**From:** Holly Palmer  
**To:** [Ryan Macindoe](#)  
**Cc:** [Judith Portelli](#); [Matthew Sales](#)  
**Subject:** MC-17-00001 SSD 8606 Hollinsworth Rd, MARSDEN PARK - Visual Impact Assessment  
**Date:** Thursday, 21 September 2017 3:00:17 PM  
**Attachments:** [image001.gif](#)  
[image002.png](#)  
[image003.png](#)  
[image004.png](#)  
[image005.png](#)  
[image006.png](#)  
[170920 Suggested Photomontage Locations \[B\].pdf](#)

We are currently preparing the visual impact assessment for SSD 8606 at Hollinsworth Road, Marsden Park.

Figure 36: Viewpoint 5 - Hassall Grove Park Reserve - Looking North - West (Photomontaged)

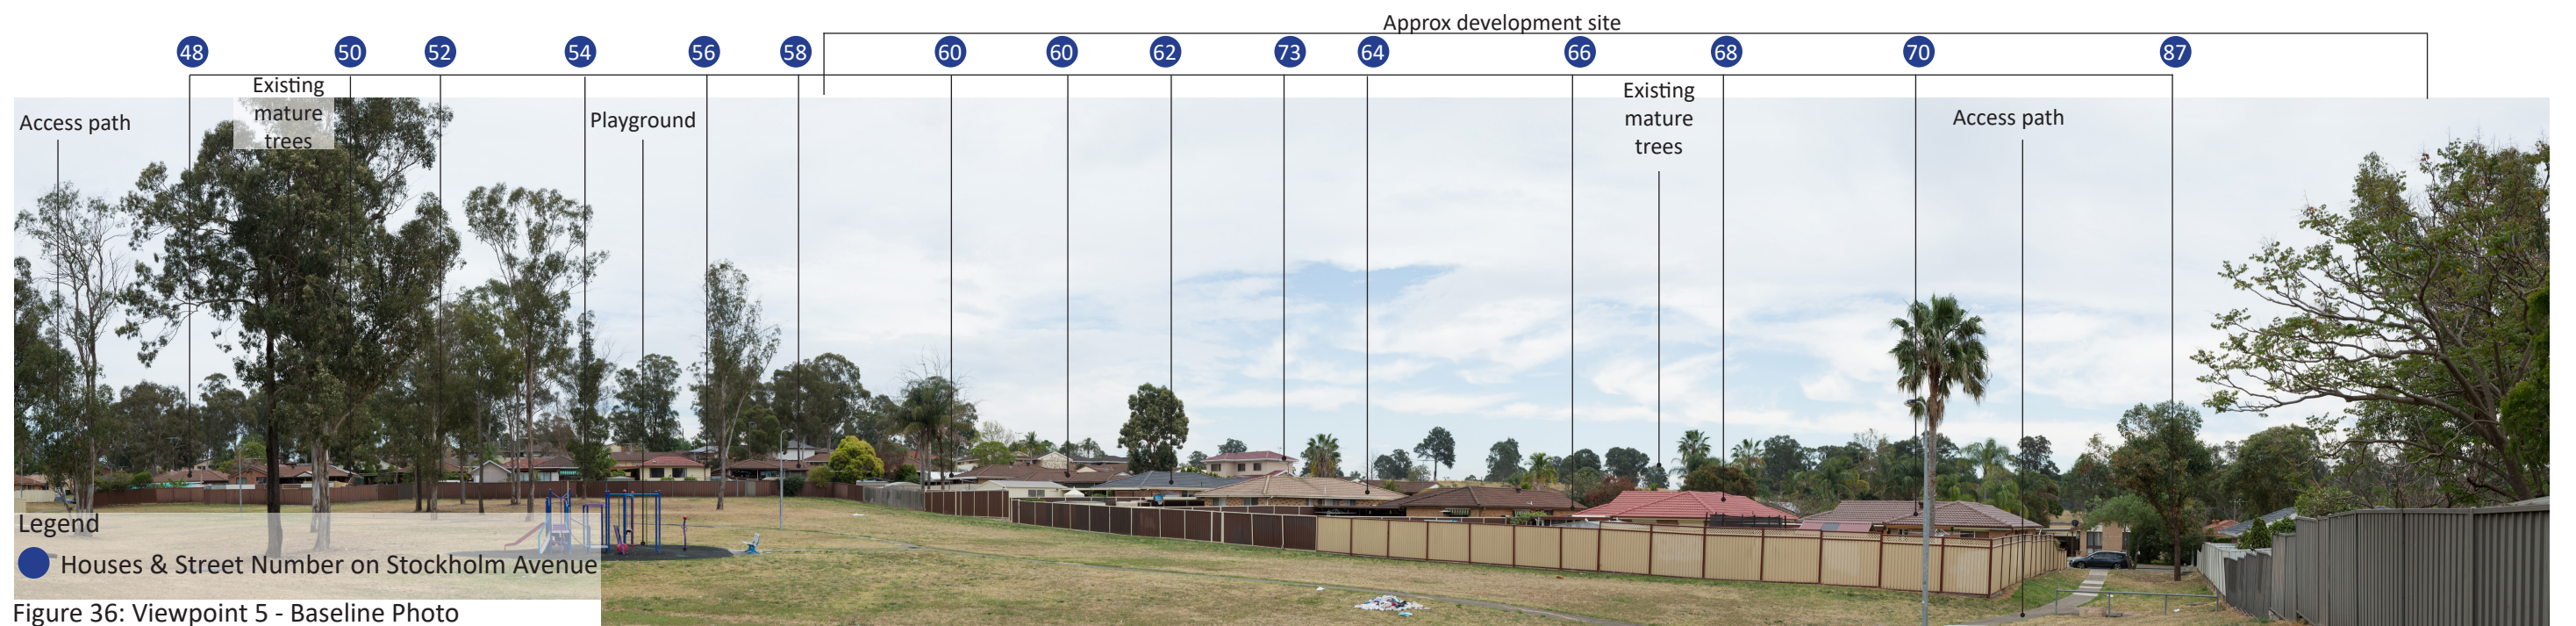
“Given that the application is for a development adjacent to residential properties, I would suggest that there would be additional key vantage points from within the neighbouring properties and not just from the street. The impact of the development will be ‘felt’ by the residents more so from within their properties, than the street - particularly their rear yards. Two additional VP’s would be useful further east and west of VP3.

I appreciate that these images are just the first draft, but I would expect to see either accurate photomontages of the existing dwellings or the existing dwellings modelled in 3d. As currently presented the images are inaccurate as the built form is not represented in 3d.”

Also please verify on the photomontages the level that the images will be taken from, for example from standing eye level, etc.

It would also be beneficial to use these images to show how there are opportunities for view lines through the buildings where possible. That is, to avoid a continual wall effect.
